Please ask for: Mrs D Johnson
Email: daun.johnson@arun.gov.uk
Telephone: 01903 737762
Our Ref: BR/47/25/PL
Your Ref:
Date: 18th March 2025

Application for Planning Permission

Development: Demolition of existing garage and erection of 1 No 2-bed chalet bungalow (self build), close up existing gateway and addition of new gateway. This application is in CIL Zone 4 and is CIL Liable as a new dwelling.
Location: 10 Nelson Road Bognor Regis PO21 2RY

Proposed Site + Roof Plan

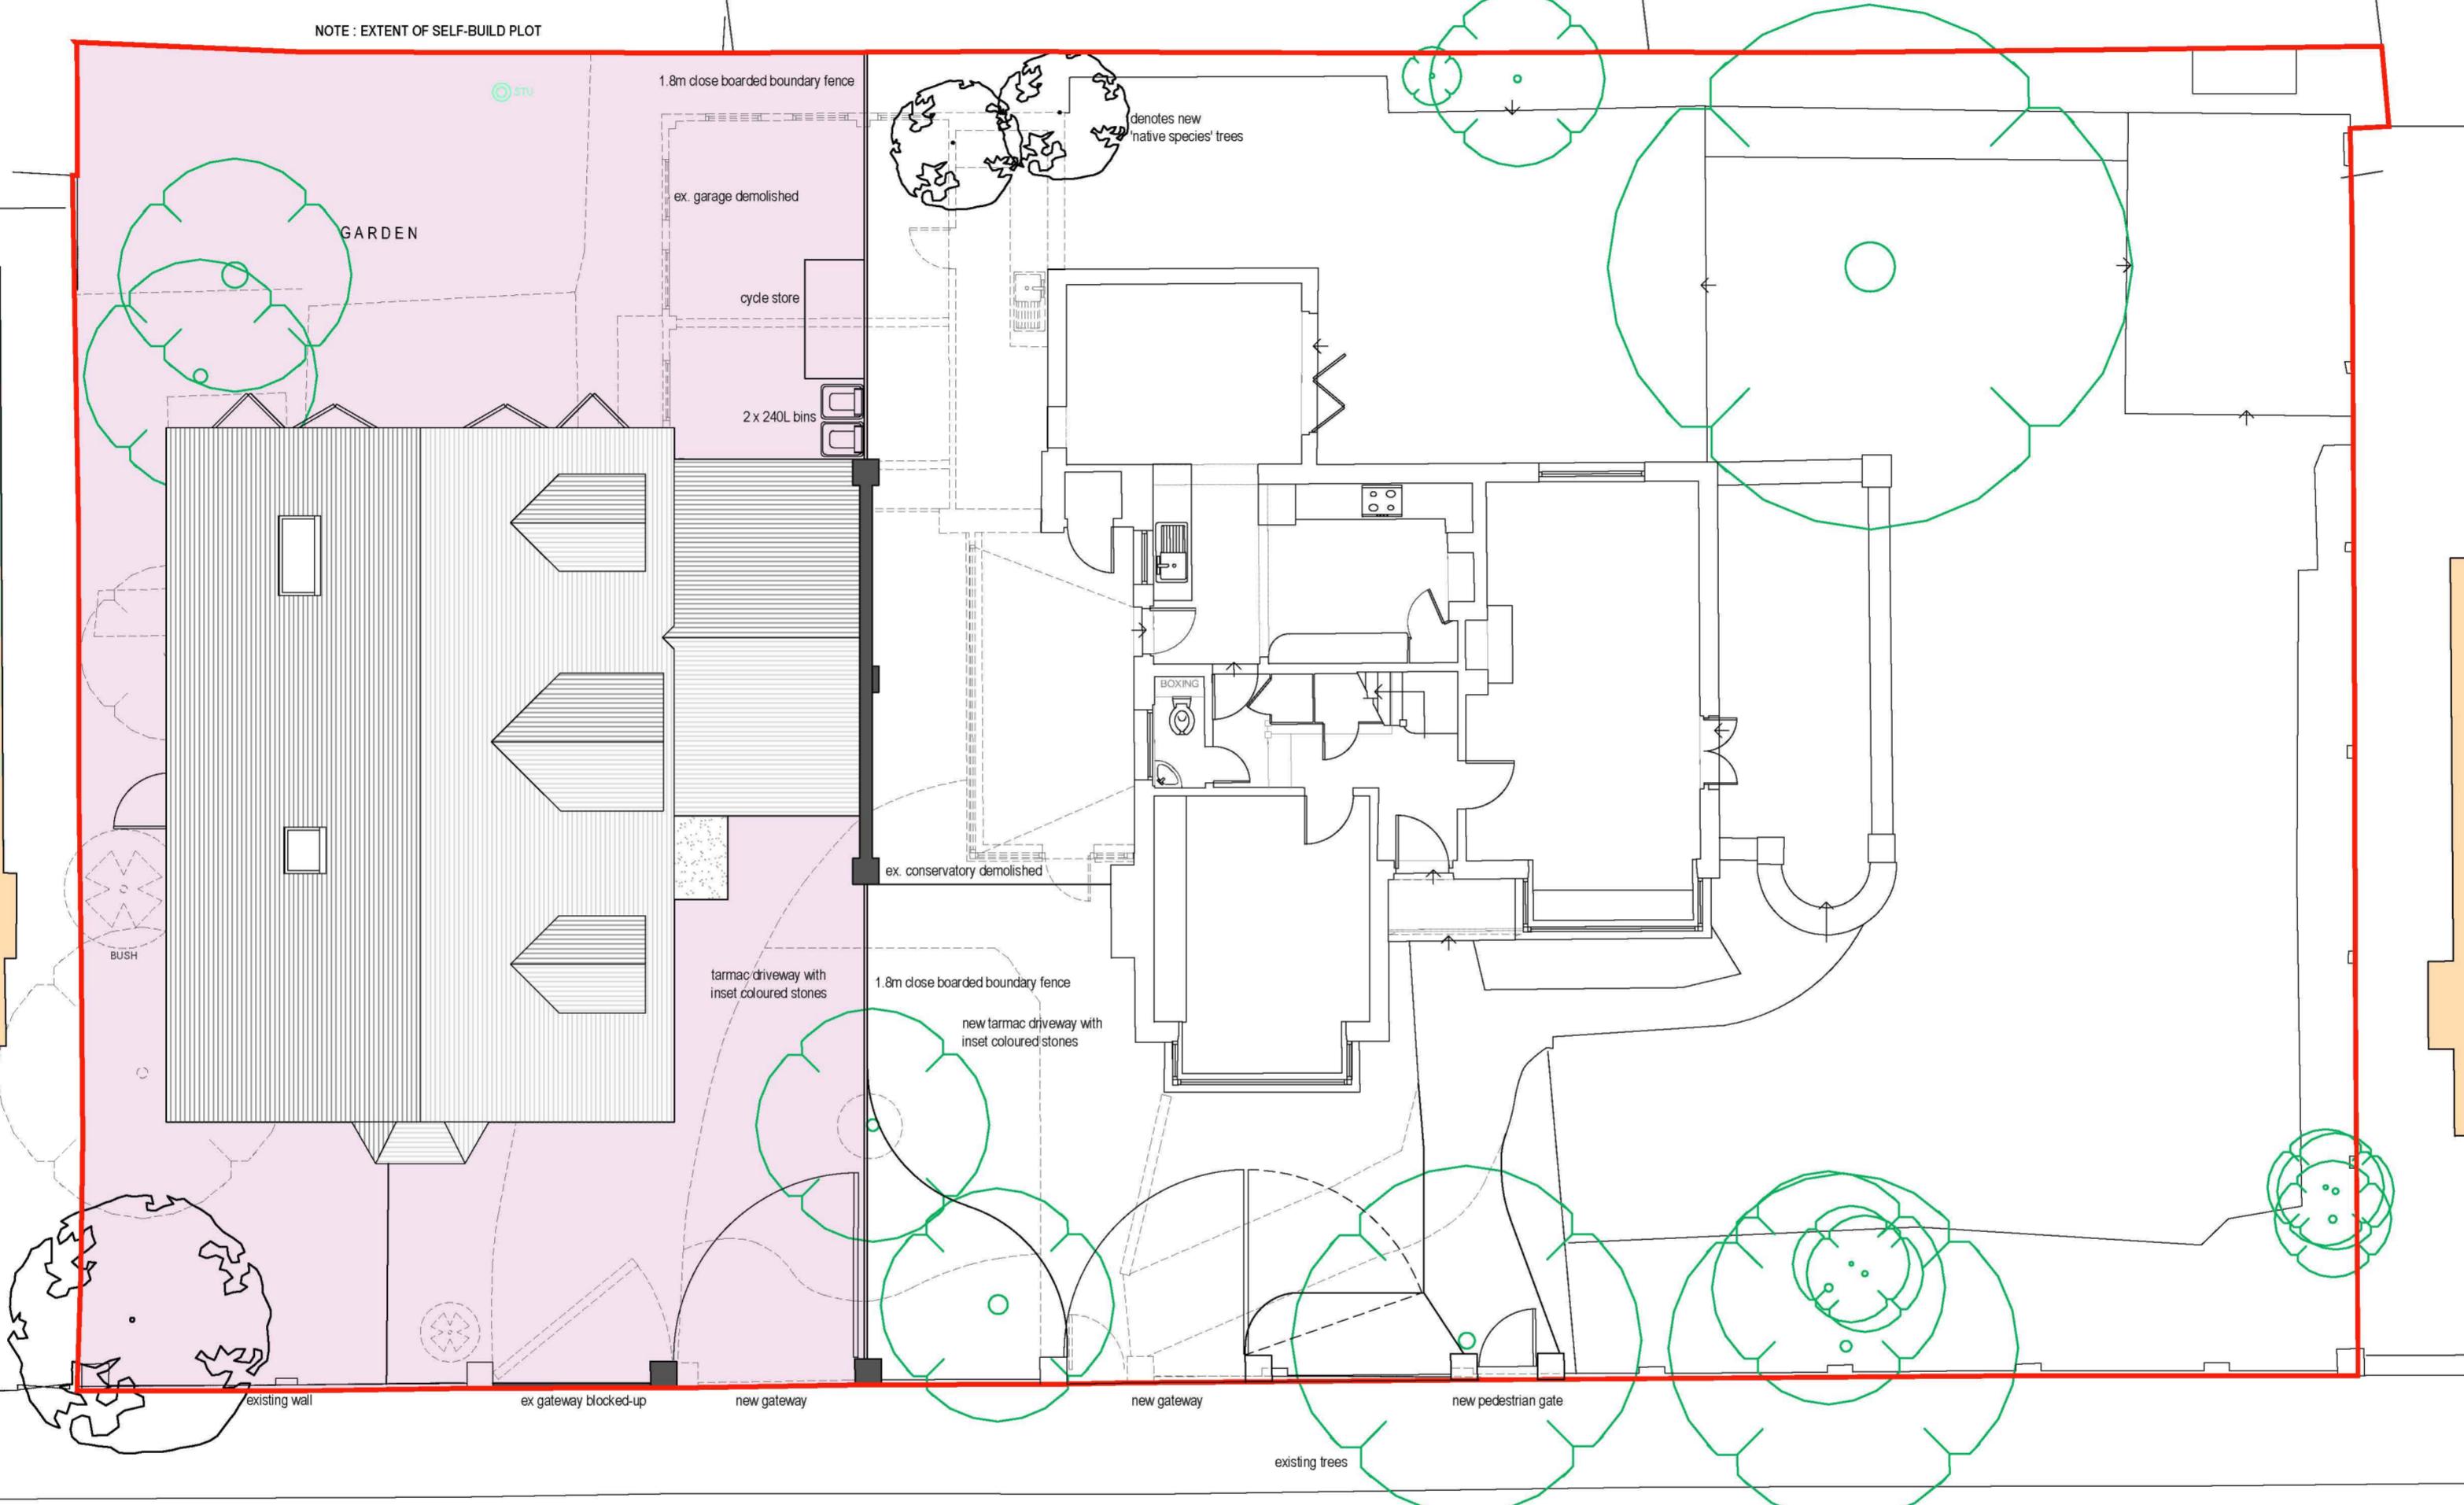
Please provide dimensions from the proposal to the site boundaries.

NORTH ELEVATION

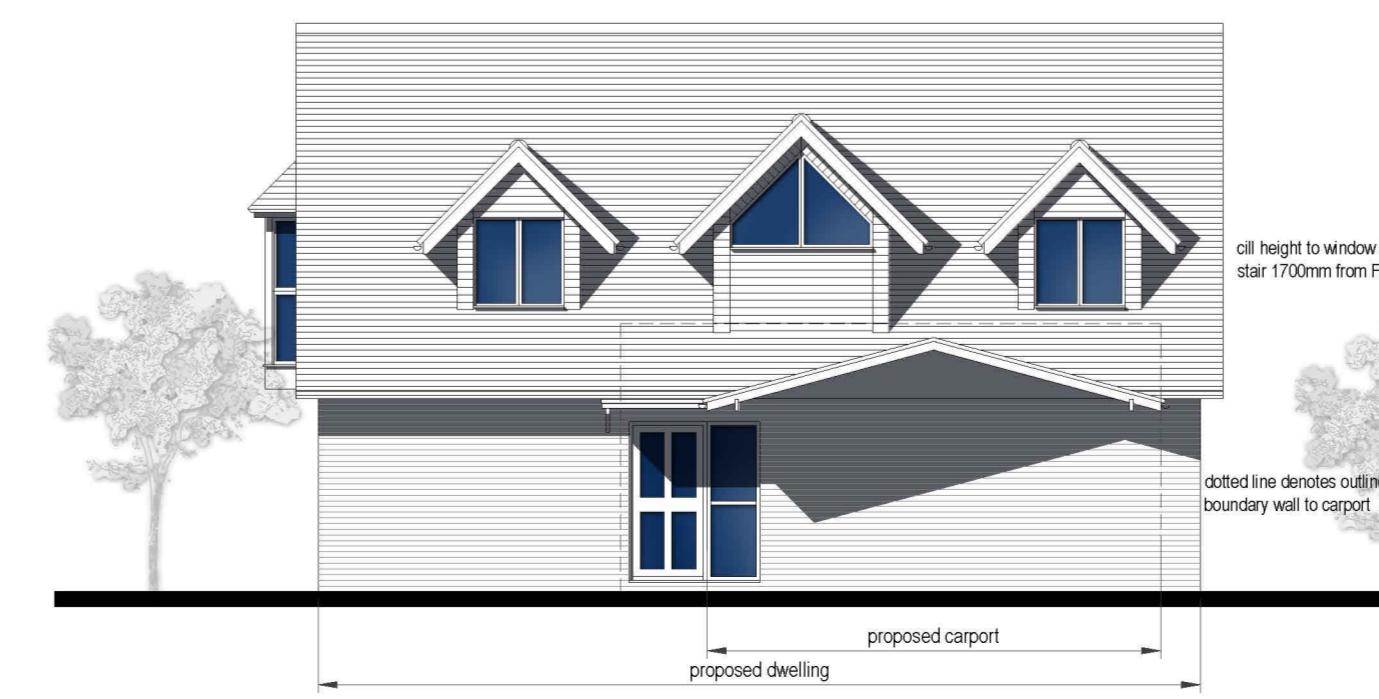
Please provide an East elevation (behind the boundary wall).
